Application No: FP/84/21/PL
Site Address: Land adjacent to The Gun Post Clyde Road Felpham PO22 7AH
Description of works: 1 No. additional self-contained beach hut with sleeping accommodation. This site is in CIL Zone 4 (Zero Rated) as other development.

Thank you for your internet representation made on 10th May 2021 which has been recorded as an objection with the comments as follows:

Proposed Site Plan
Scale 1 : 200

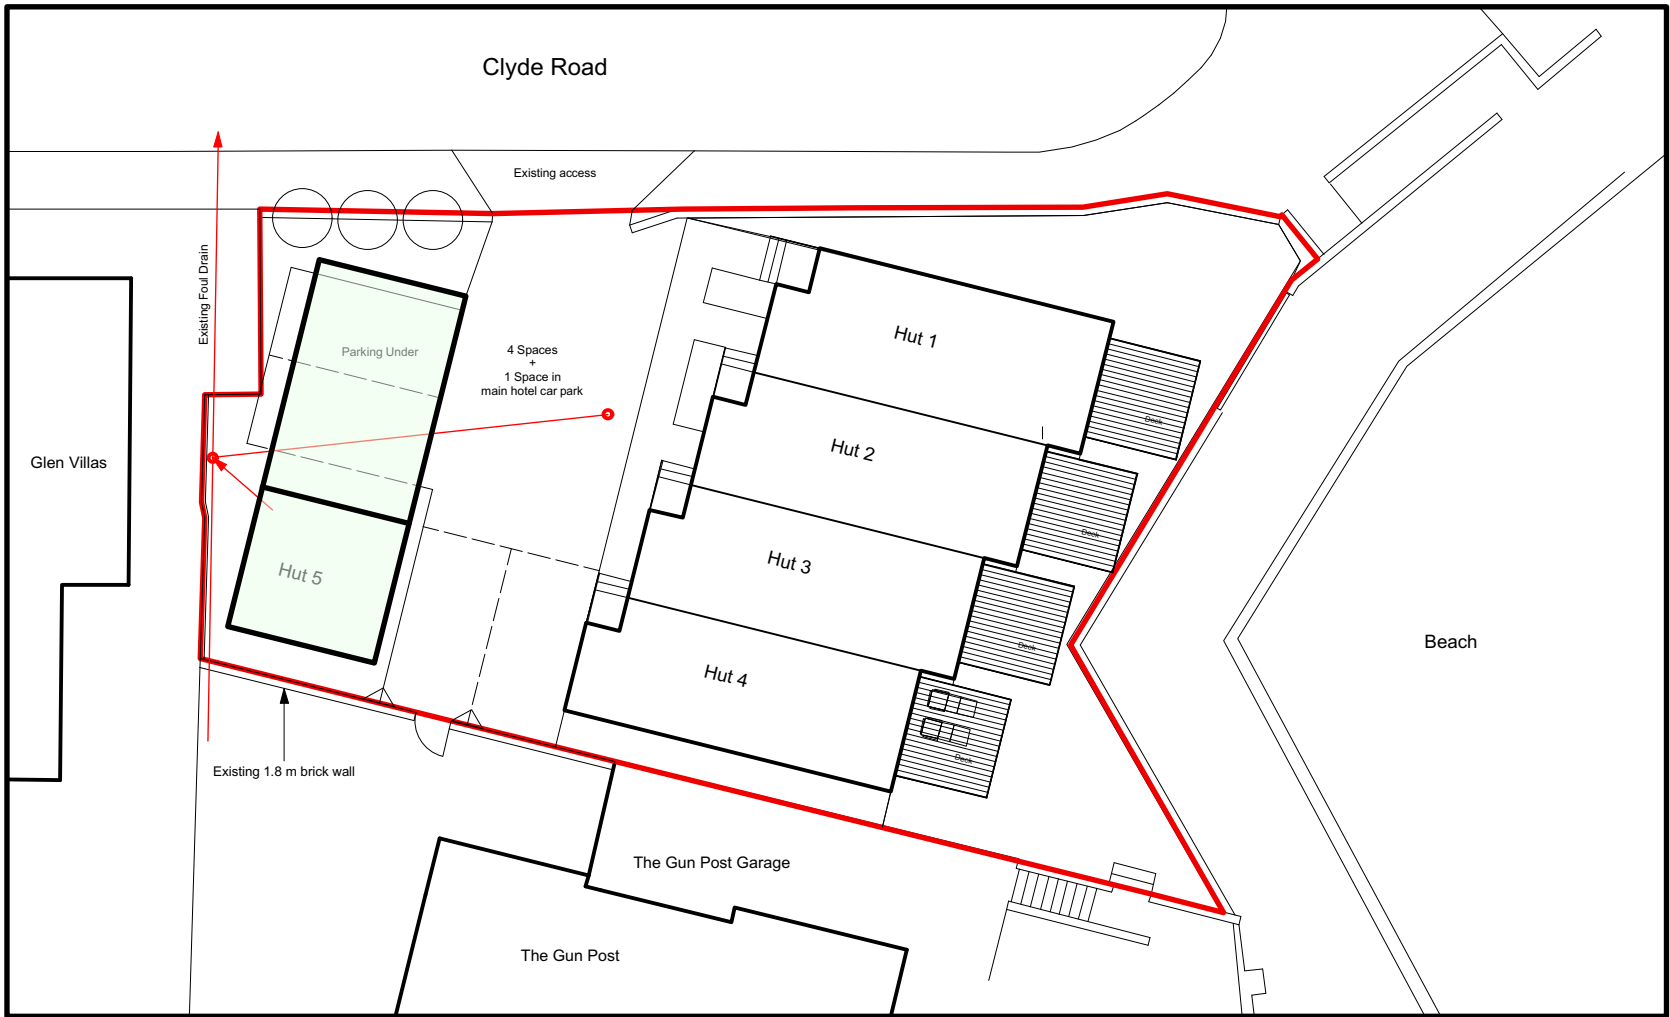
This is not a large site so this huge Beach Hut is over development, it is too high and some windows will overlook the property I live in! Also car parking looks limited as the turn around to the under hut spaces is going to be tight, people in the huts that are already there tend to park in the hotel. Ar park!
